Application No: K/17/22/PL
Site Address: Panorama Golden Acre Kingston BN16 1QP
Description of works: Conversion of existing 2 No flats into 1 No dwelling, single-storey extension with a sloping roof, new porch on ground floor, conservatory at first floor and roof extension, replacement of existing windows, doors and roof tiles. This site is in CIL Zone 4 and is CIL Liable as new dwelling.

Thank you for your internet representation made on 28th July 2022 which has been recorded as an objection with the comments as follows:

Drawing Title: Proposed Second Floor Roof Extension
Planning

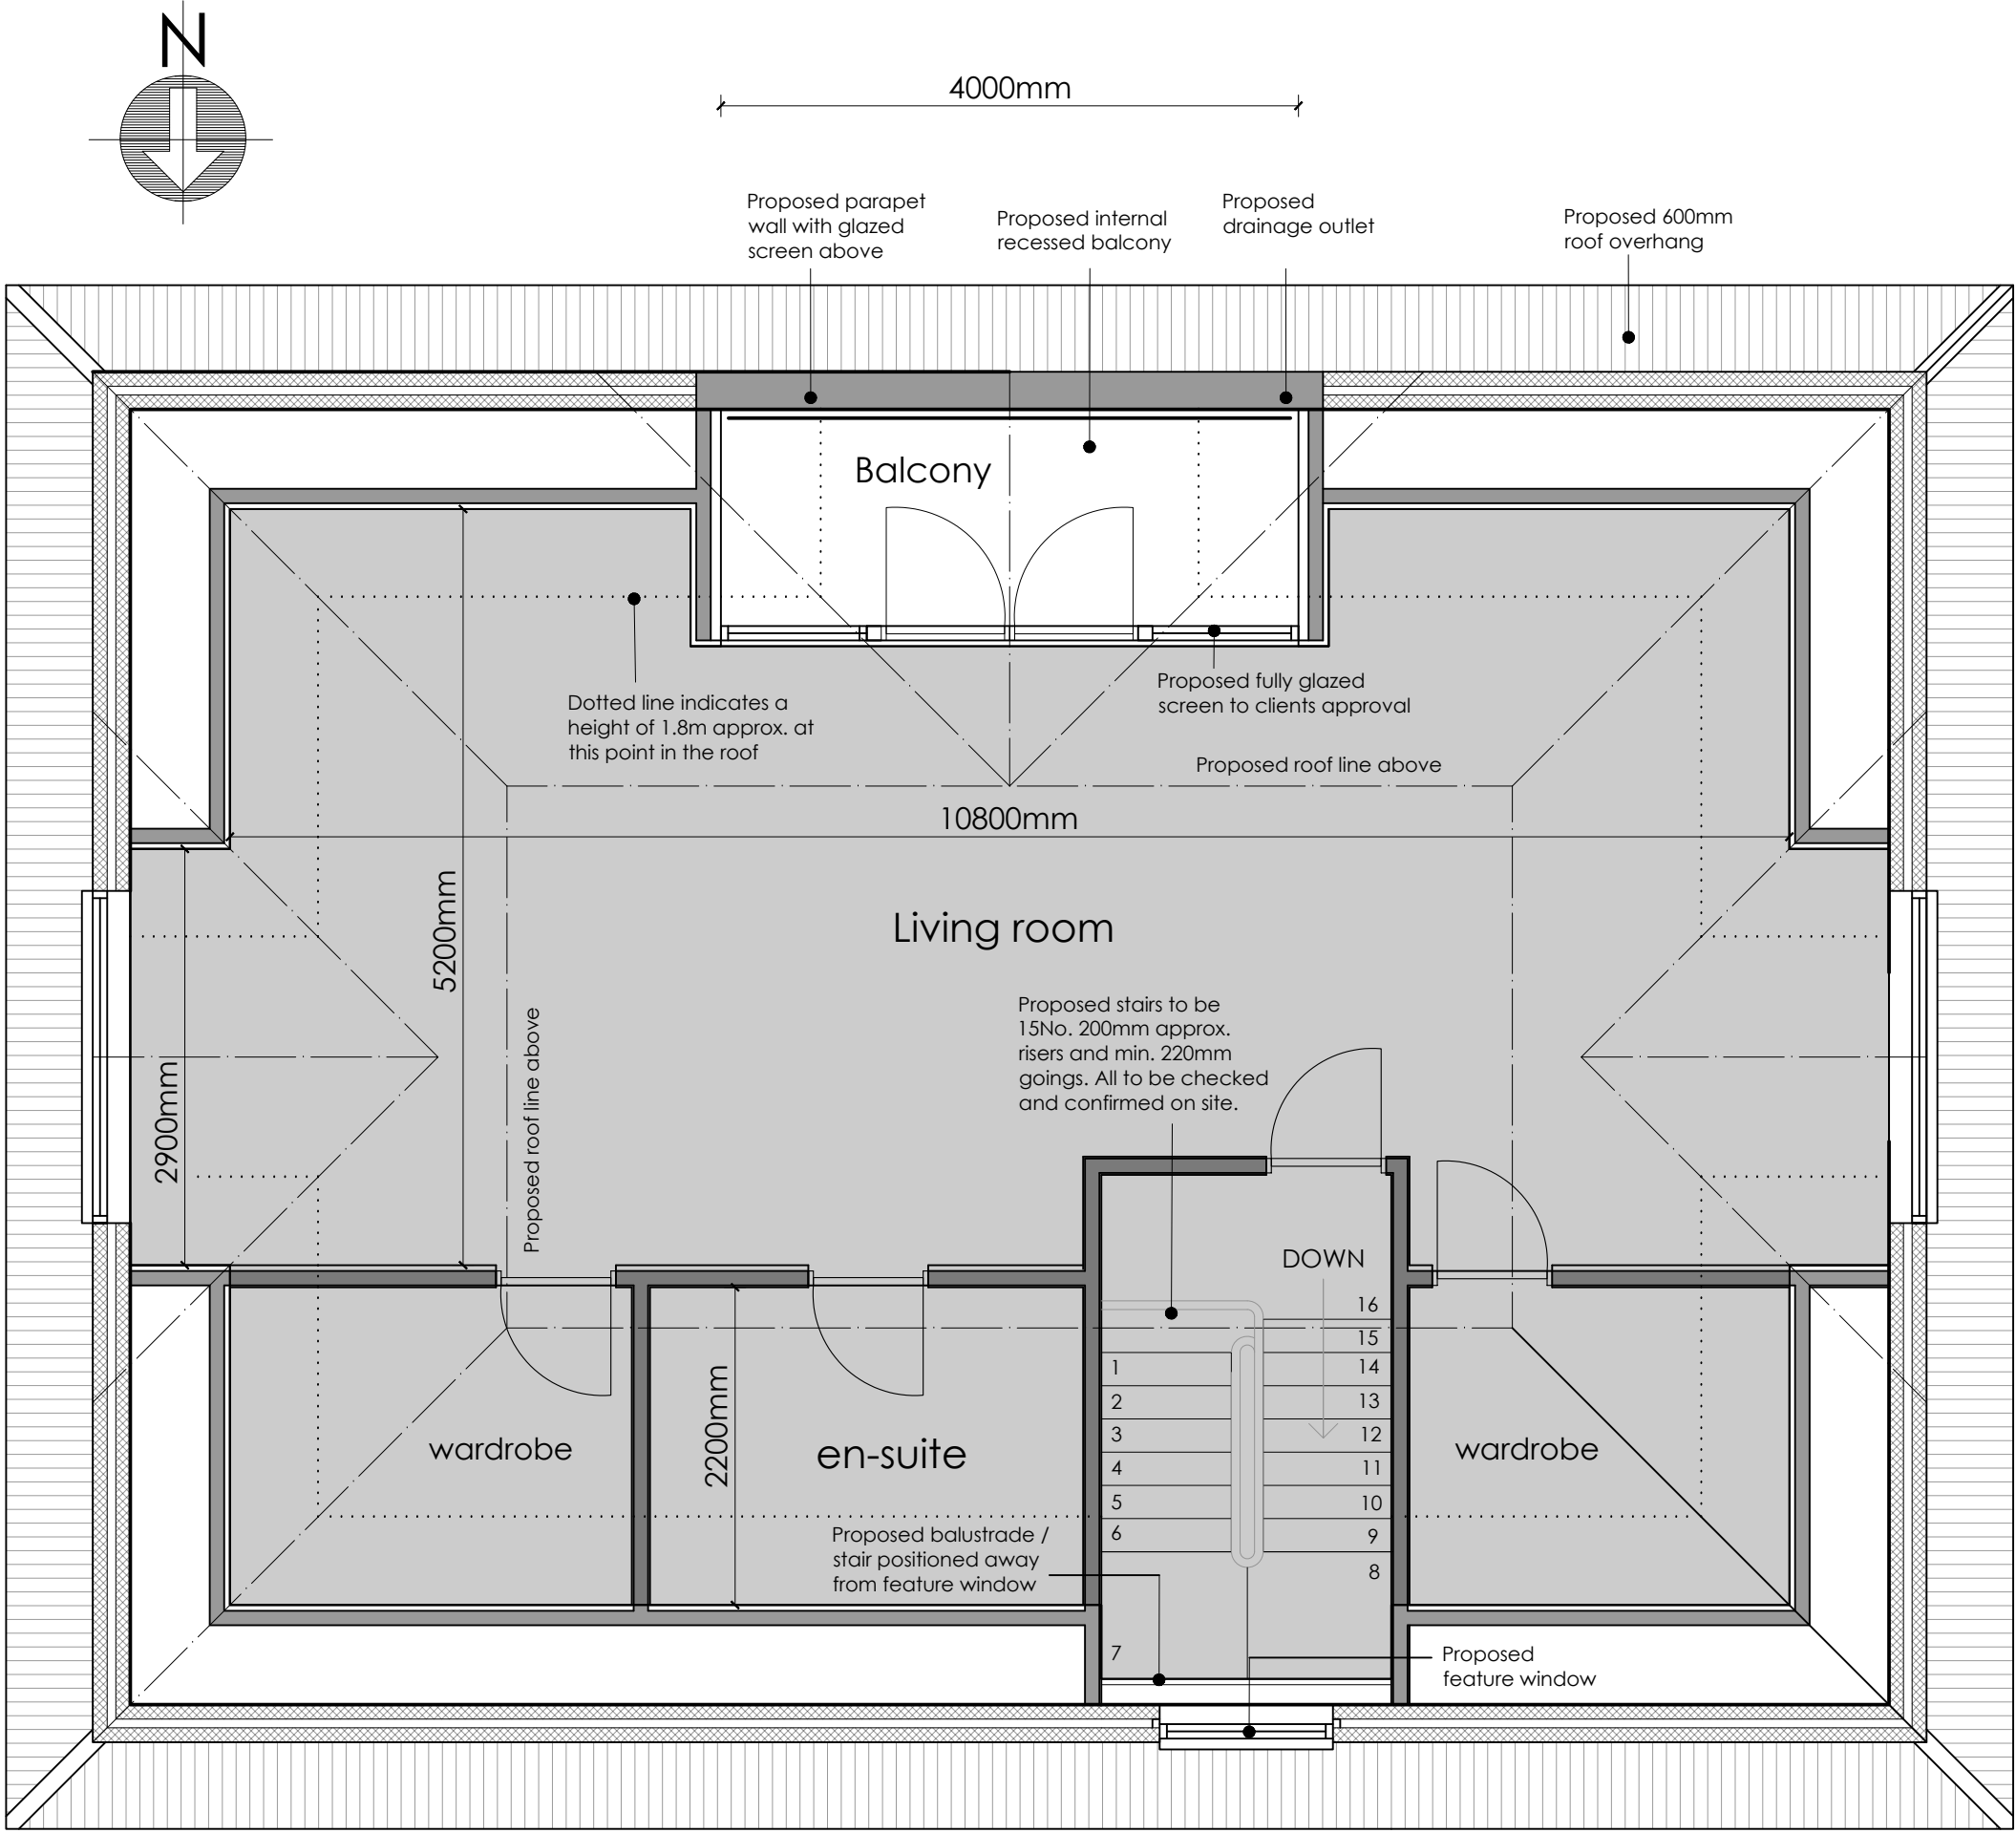
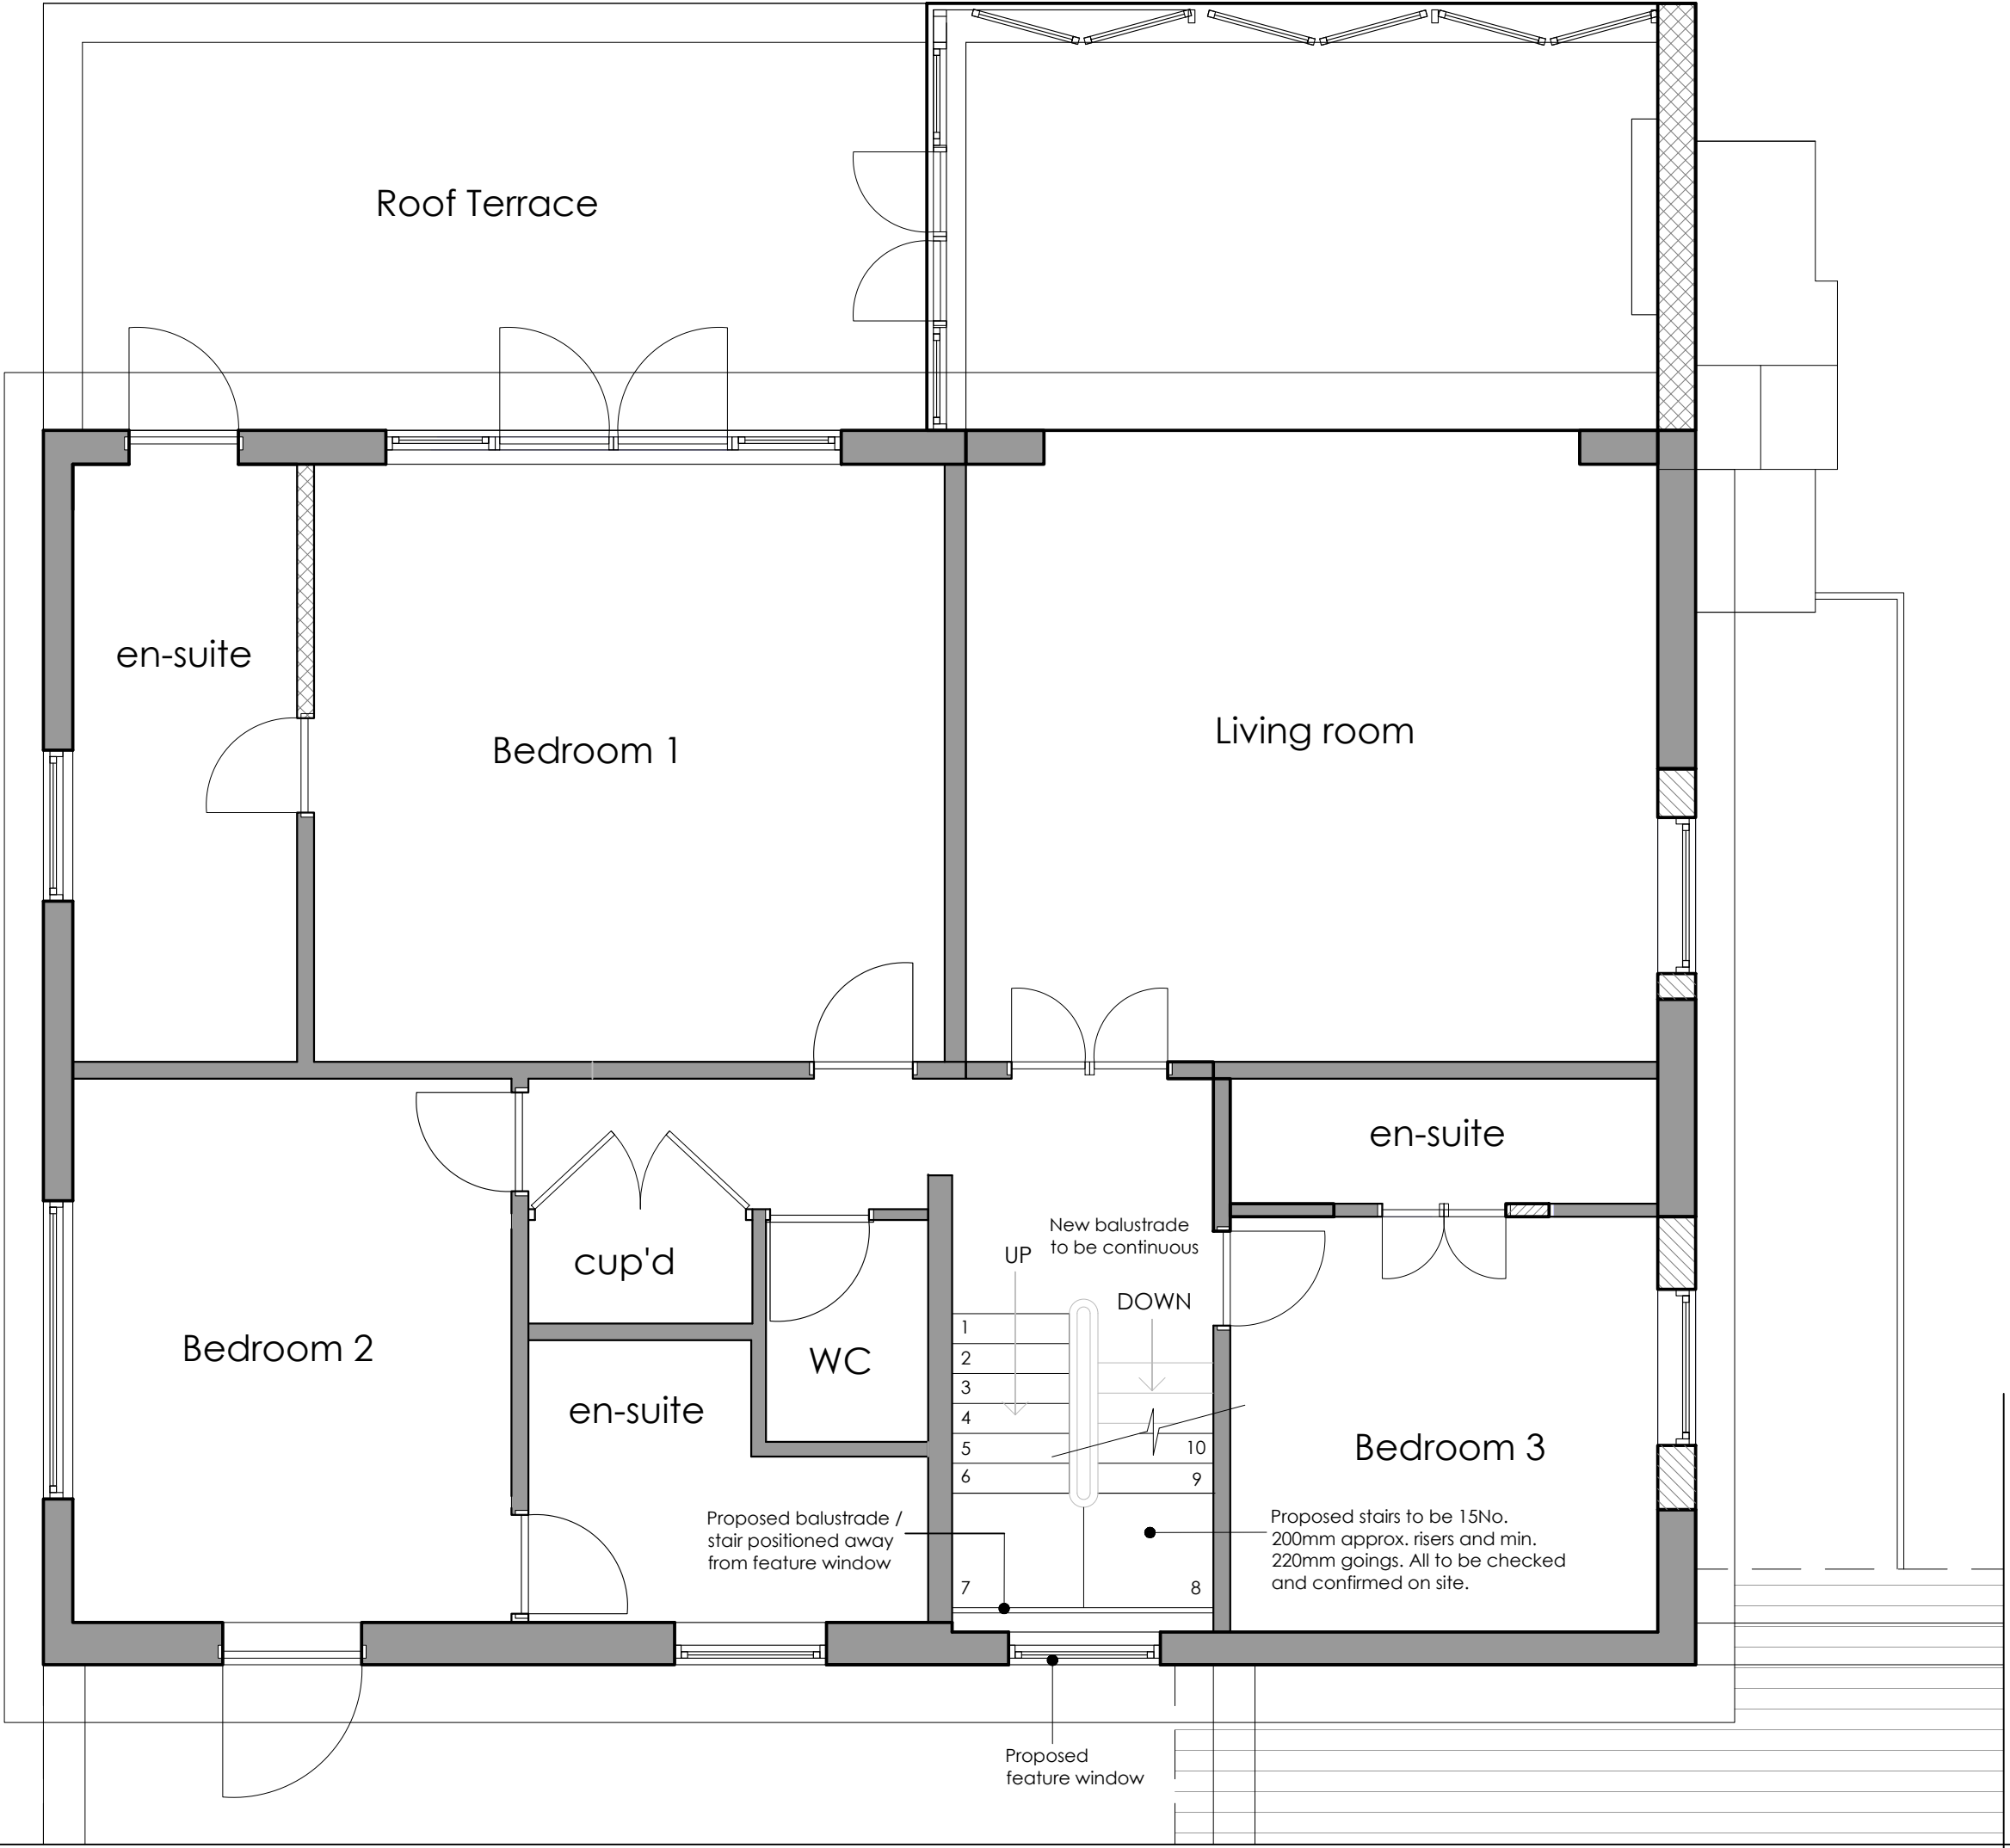
2. There needs to be an understanding of the impact the additionality of this development will have upon us. With the enlargement of the roof space and raised ridge height and the inclusion of both the east elevation and north elevation windows within the roof to create the second floor will lessen our privacy even further. The northerly elevation roof window will look directly down into our main bedroom that is on the south west corner of our property, let alone the eastern elevation roof windows that will expose the totally of our rear garden with

no opportunity of screening at that height. The enlarged windows will allow increased opportunity for observations by the occupants of Panorama to not only the Greensward but the entire southern aspect and into the rooms of our property.
